CITY OF ALBUQUERQUE

March 9, 2018

Re: Ninja Fitness Academy, 8600 Pan American Fwy NE
Request for Certificate of Occupancy
Transportation Development Final Inspection
Engineer's Stamp dated 12-18-17 (C18D005)
Certification dated 3-8-18

1 OF 1
SHEET **TCL**

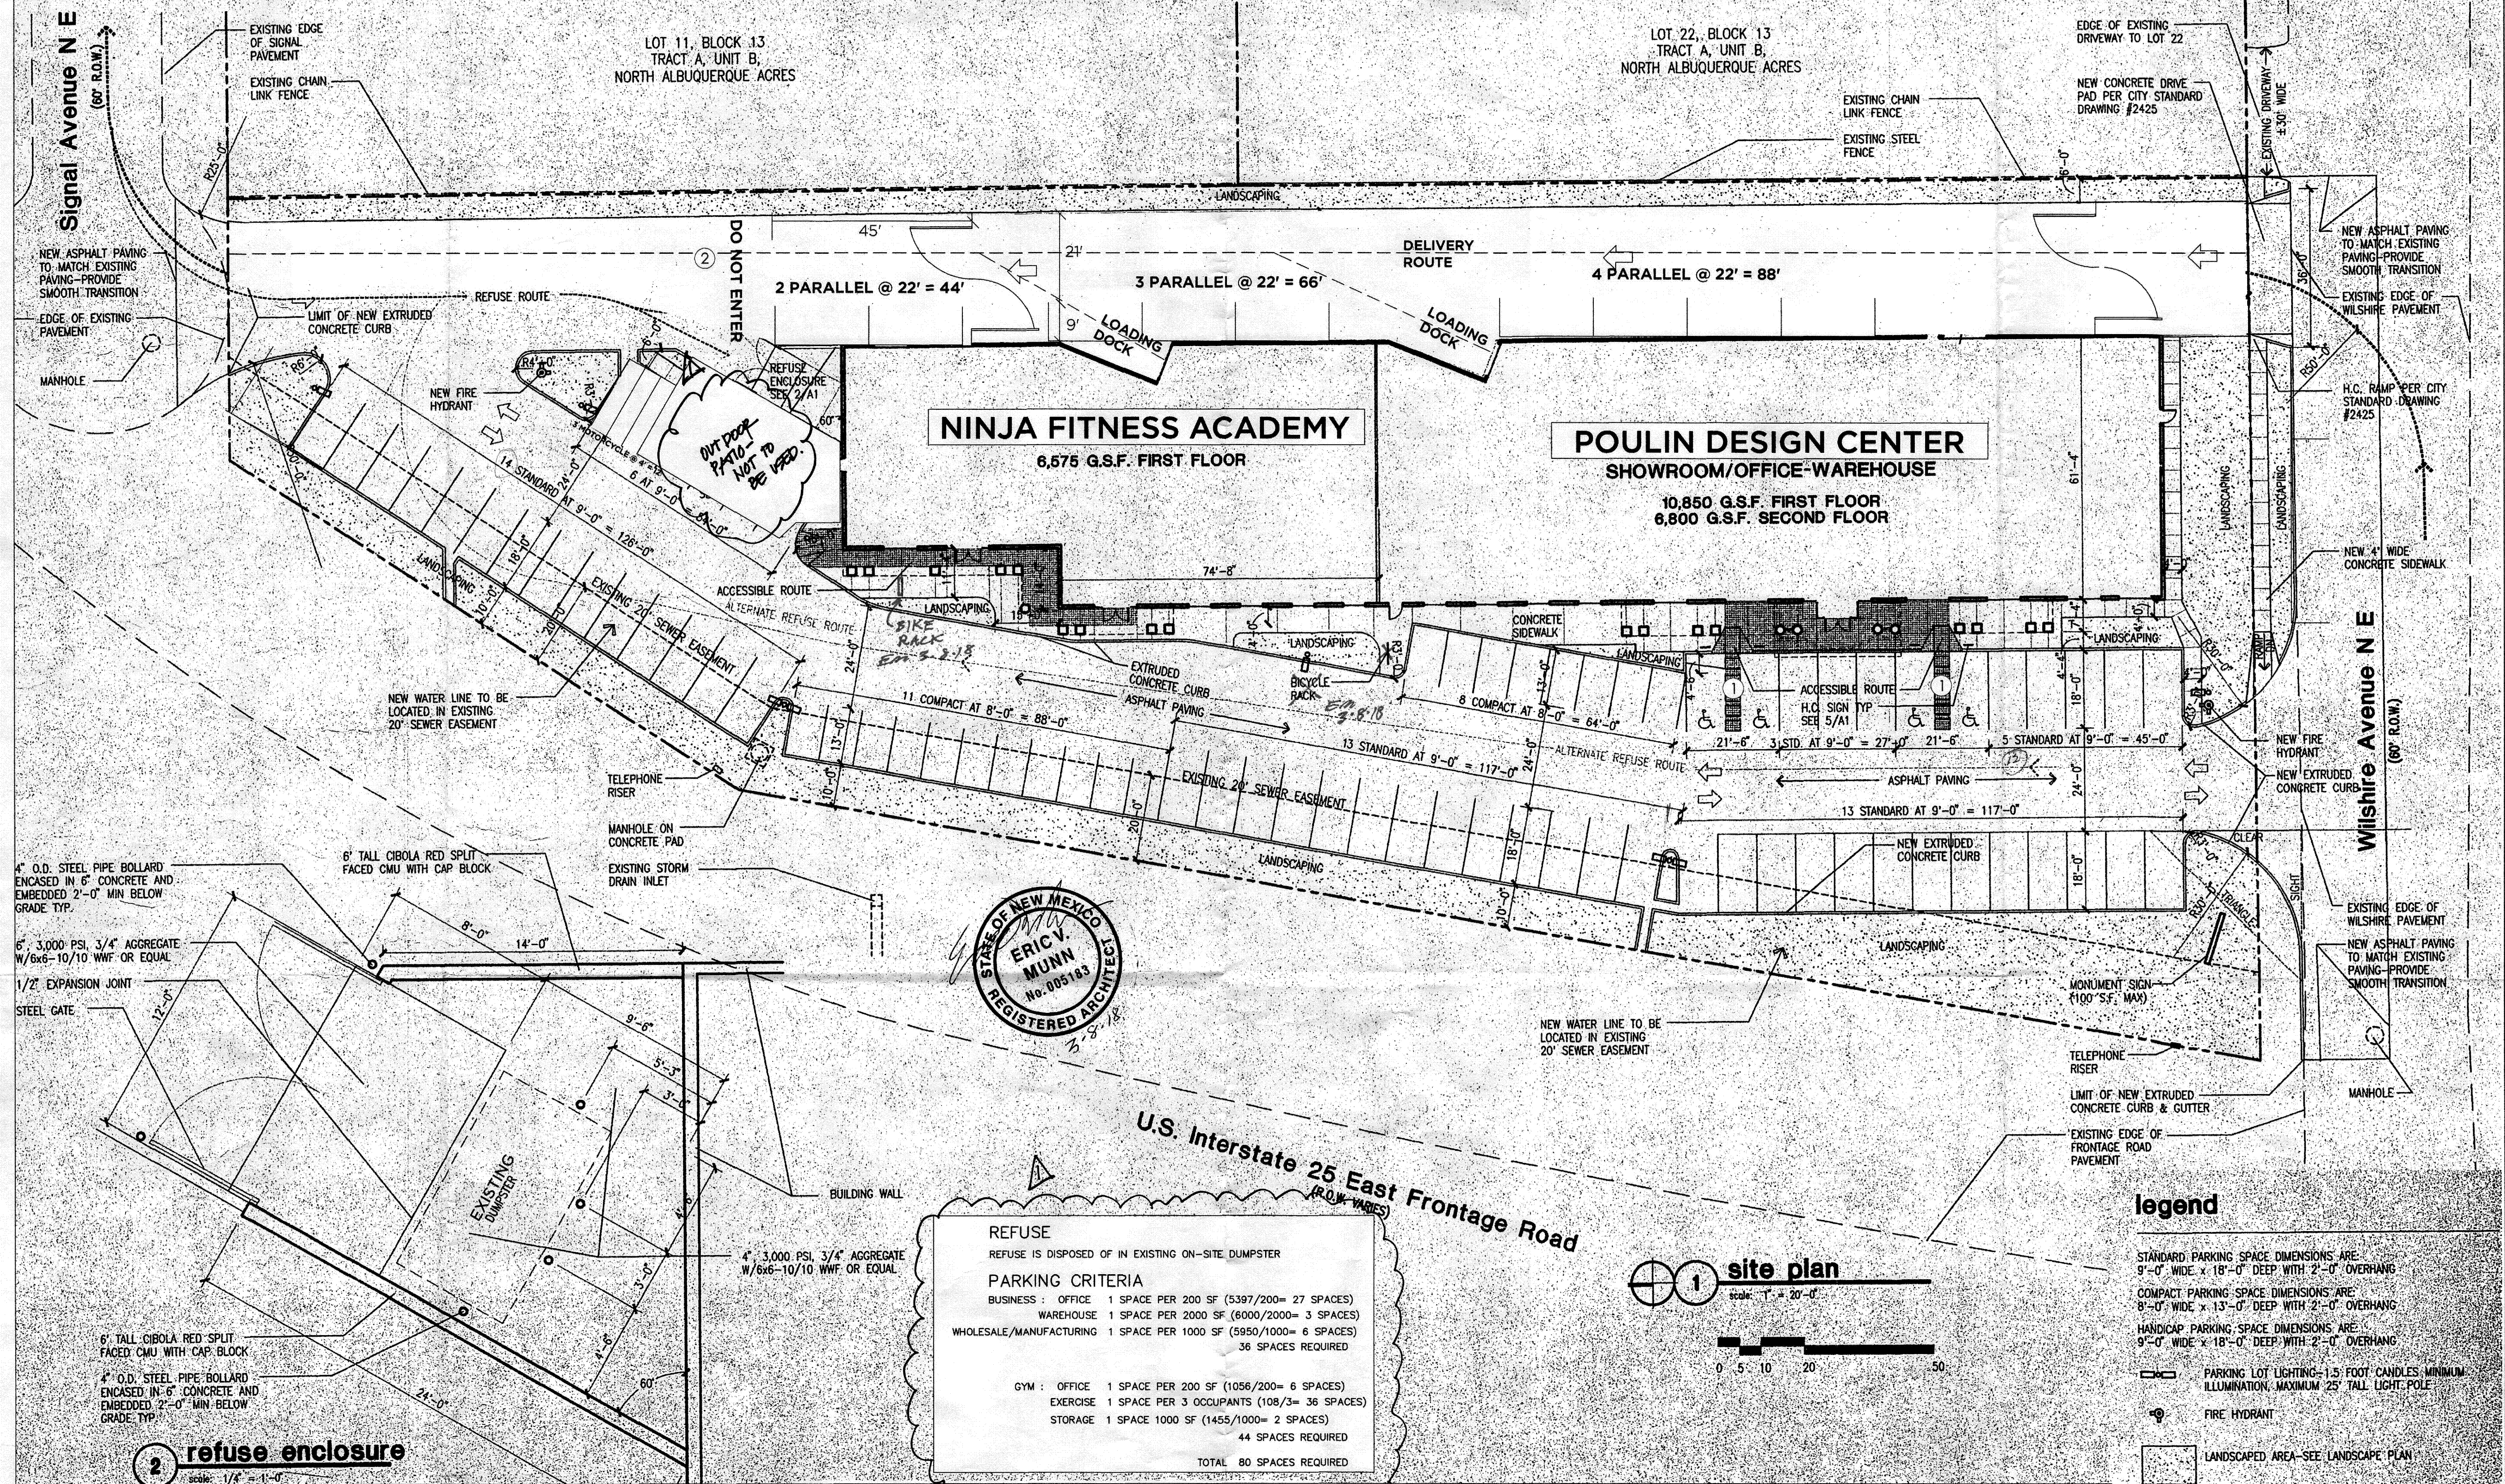
- Label the compact parking spaces by placing the words "**COMPACT**" on the pavement of each space
- Remove ADA marking from pavement on the northwest side of the building.
